## **Peartree Hill Solar Farm**

# **Environmental Statement Addendum**

Application Document Ref: EN010157/APP/8.2

July 2025

- | No. | Viewpoint |

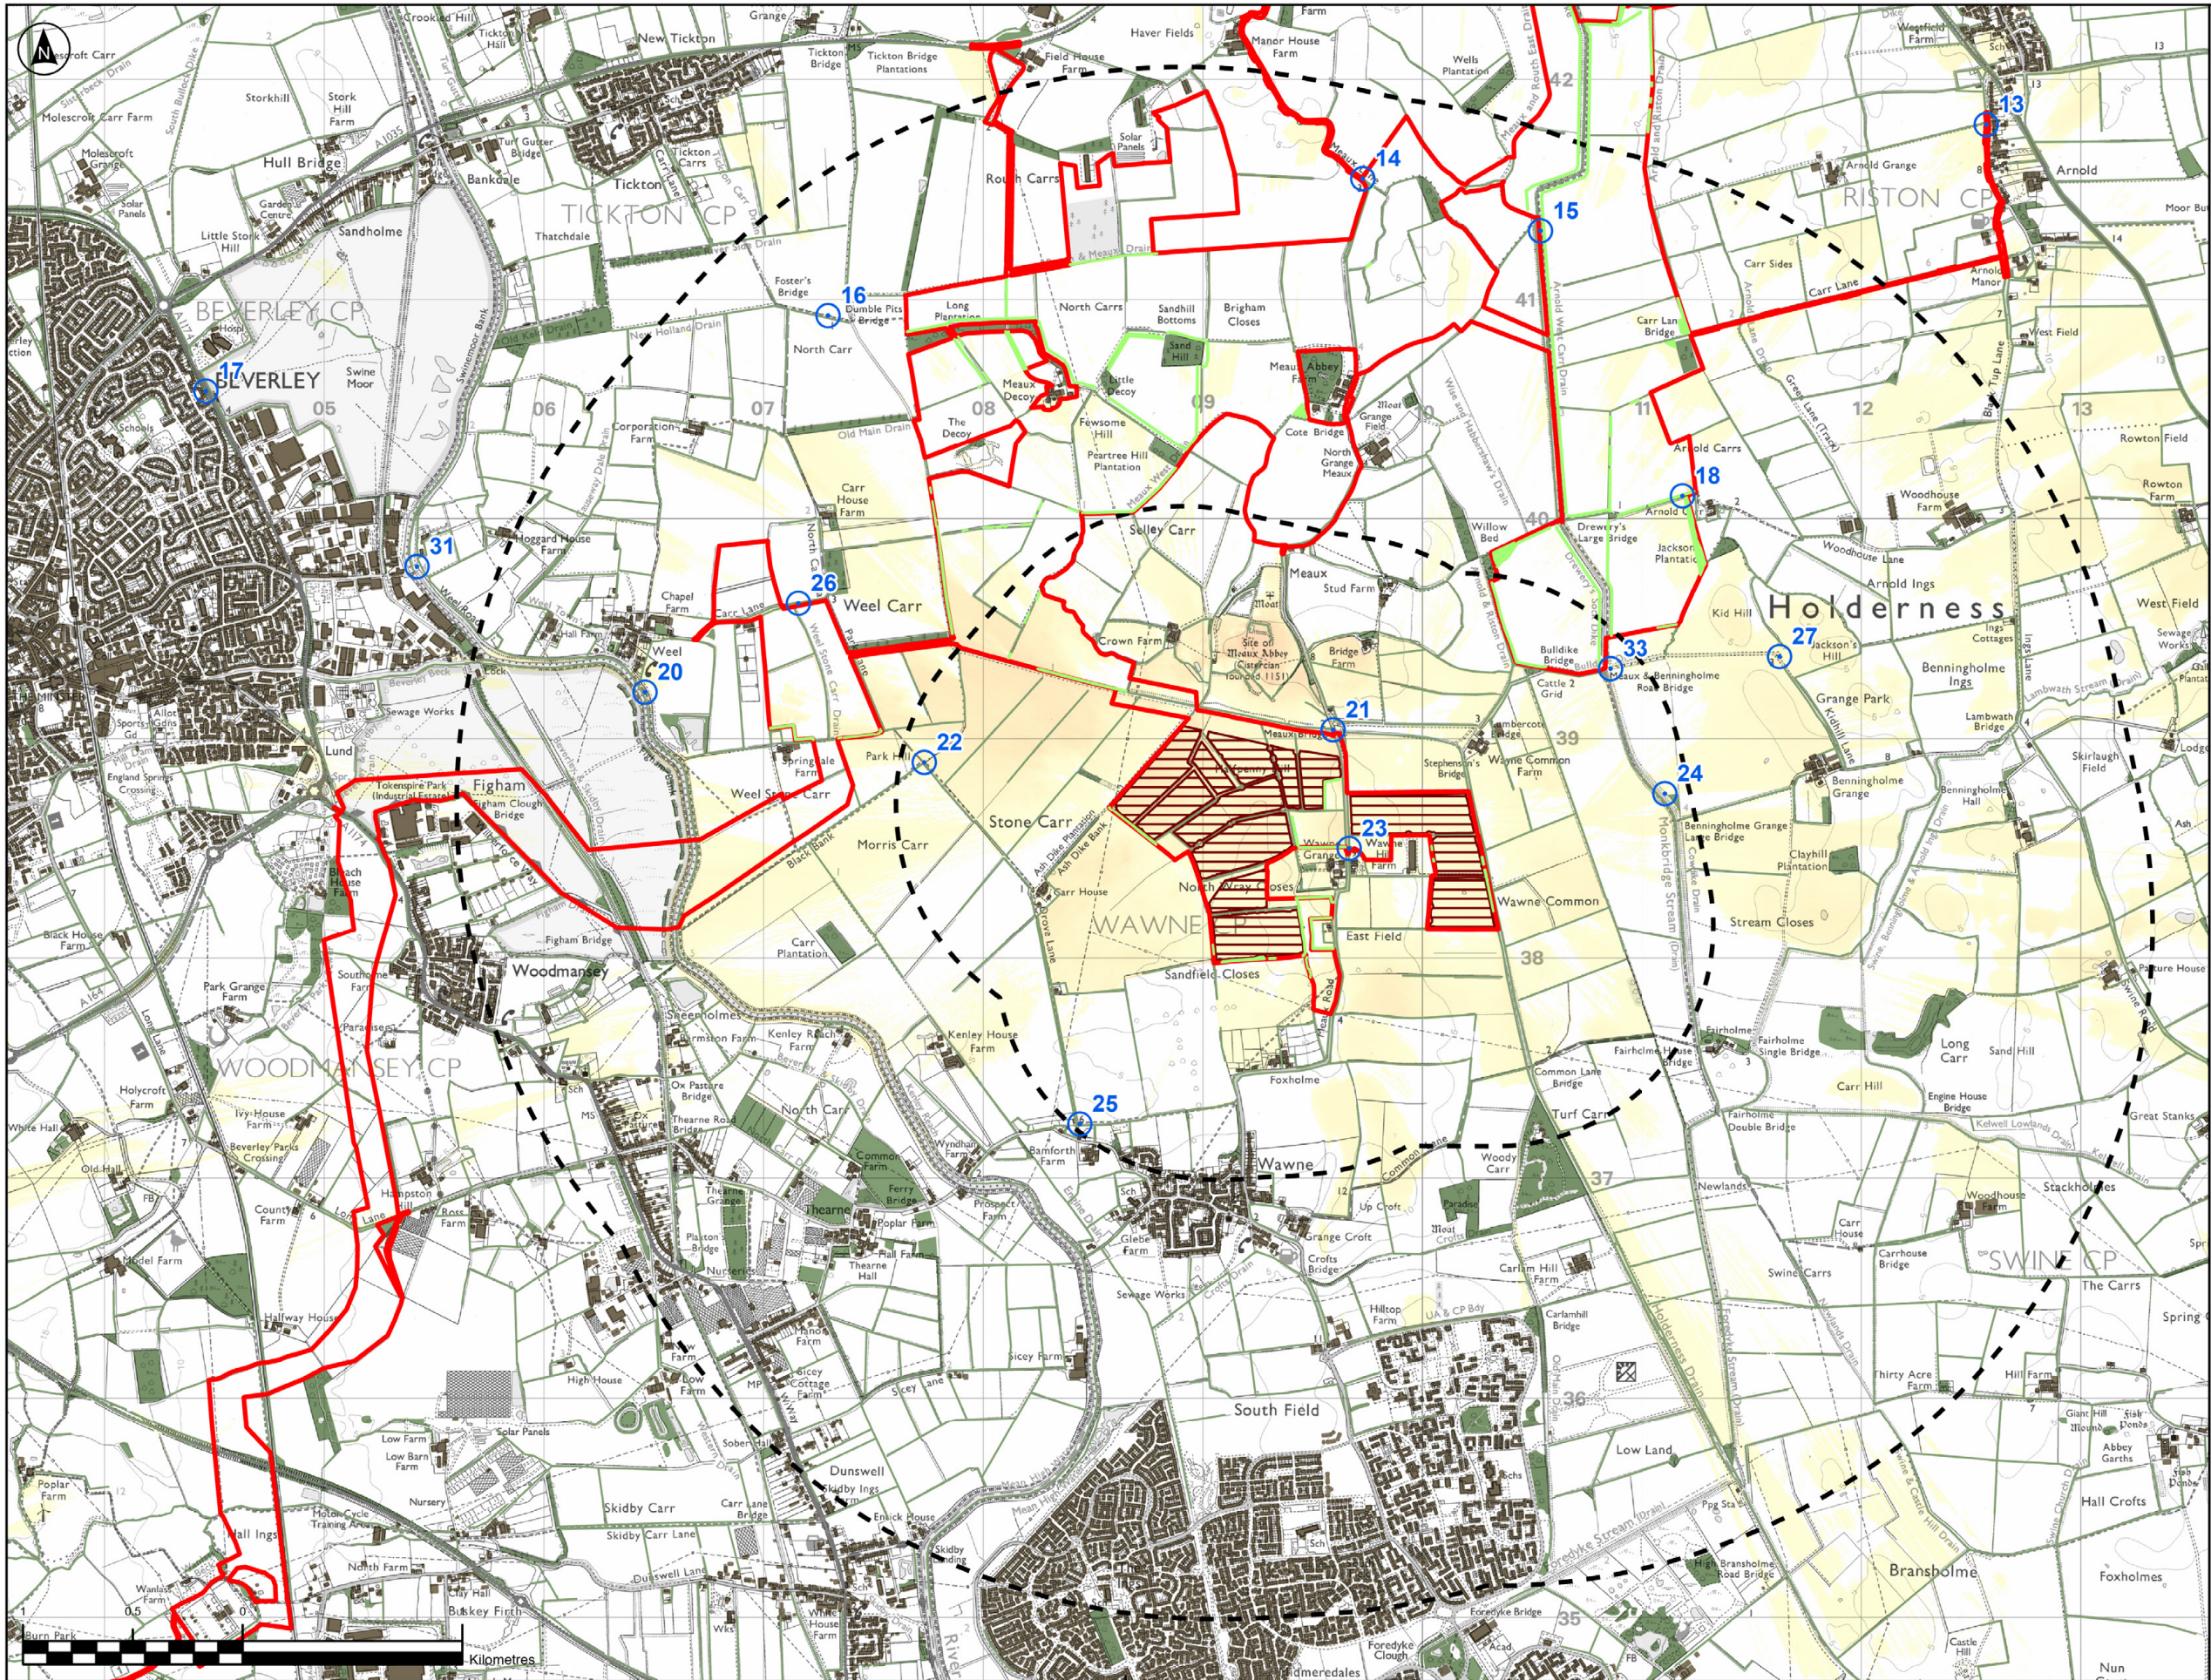
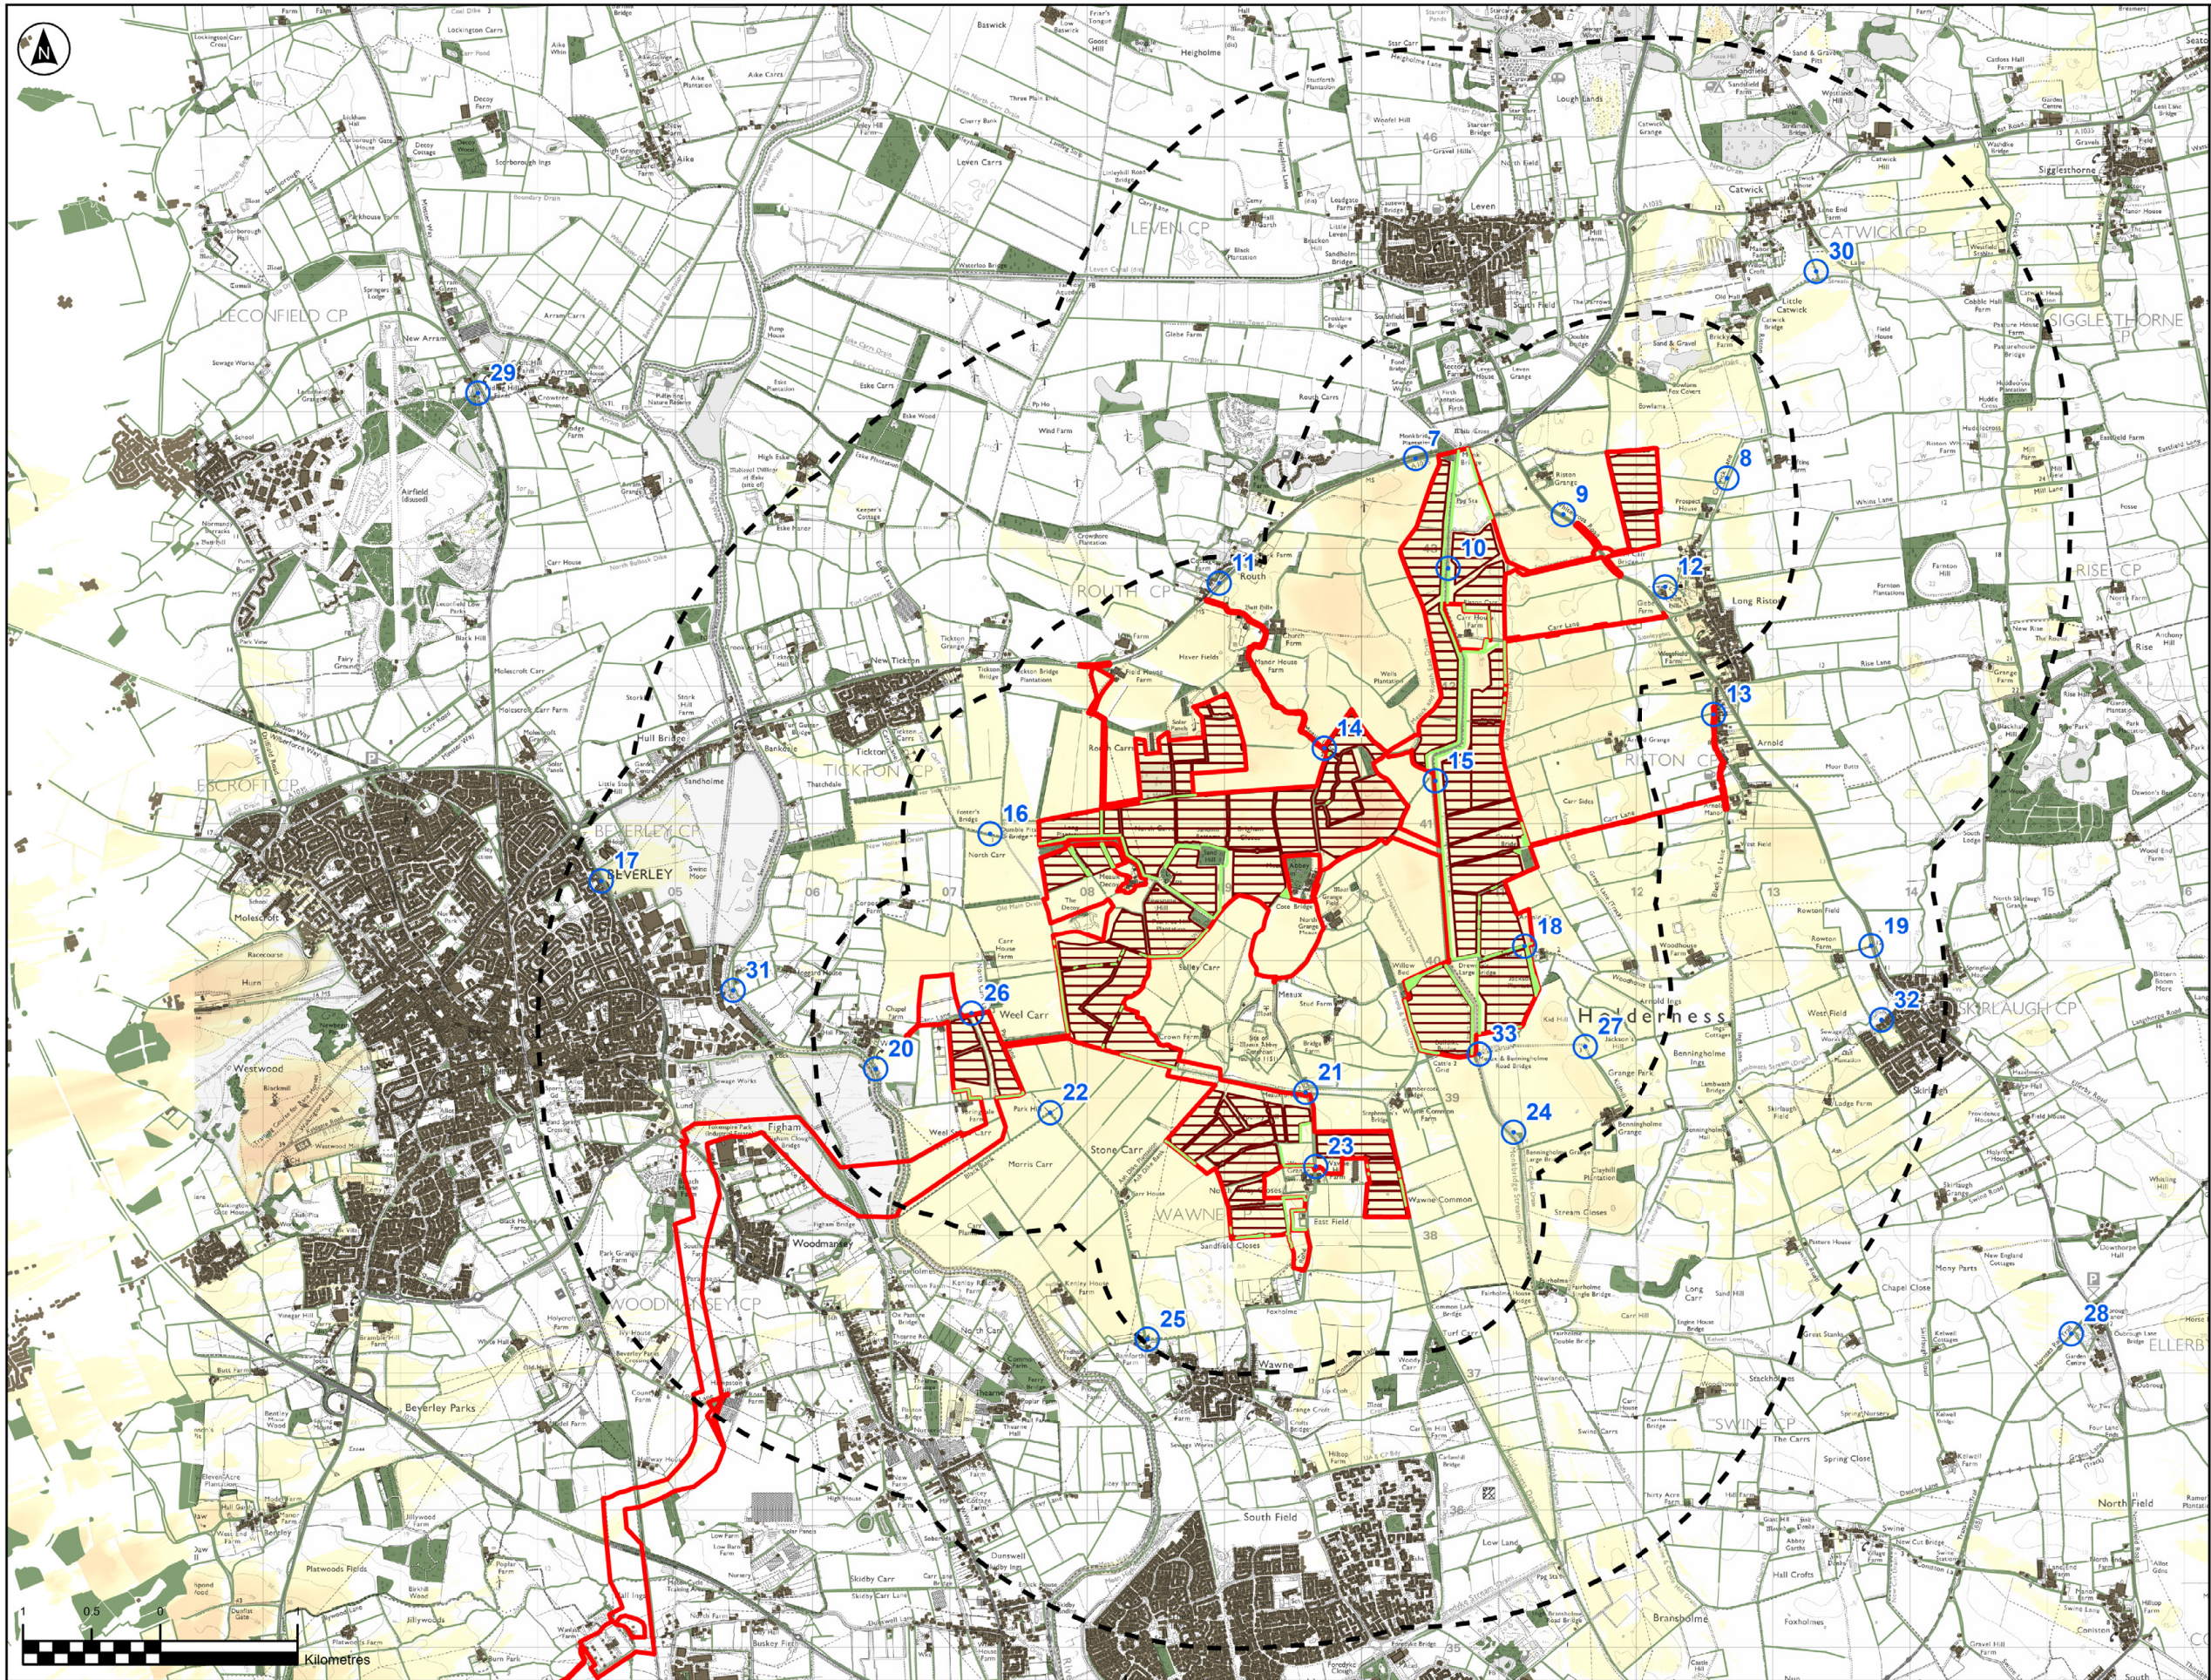
ES Volume 3, Figure 11.8: Solar PV Modules Year 10 Post Mitigation ZTV [APP-079]	<p>Figure 11.8 requires amendment to reflect the removal of a section of solar array from Land Area B as part of change/correction 1.</p> <p>Figure 11.8 also requires amendment to reflect the removal of plots 10-4, 10-5 and 10-6 as part of change/correction 2.</p>	
ES Volume 3, Figure 12.1: Study Area for Noise – Construction and Decommissioning [APP-080]	Figure 12.1 requires amendment to reflect the removal of plots 10-4, 10-5 and 10-6 as part of change/correction 2.	
ES Volume 3, Figure 12.2: Study Area for Noise – Operation (including Maintenance) [APP-081]	Figure 12.2 requires amendment to reflect the removal of plots 10-4, 10-5 and 10-6 as part of change/correction 2.	
ES Volume 3, Figure 12.3: Baseline Noise Monitoring Locations [APP-082]	Figure 12.3 requires amendment to reflect the removal of plots 10-4, 10-5 and 10-6 as part of change/correction 2.
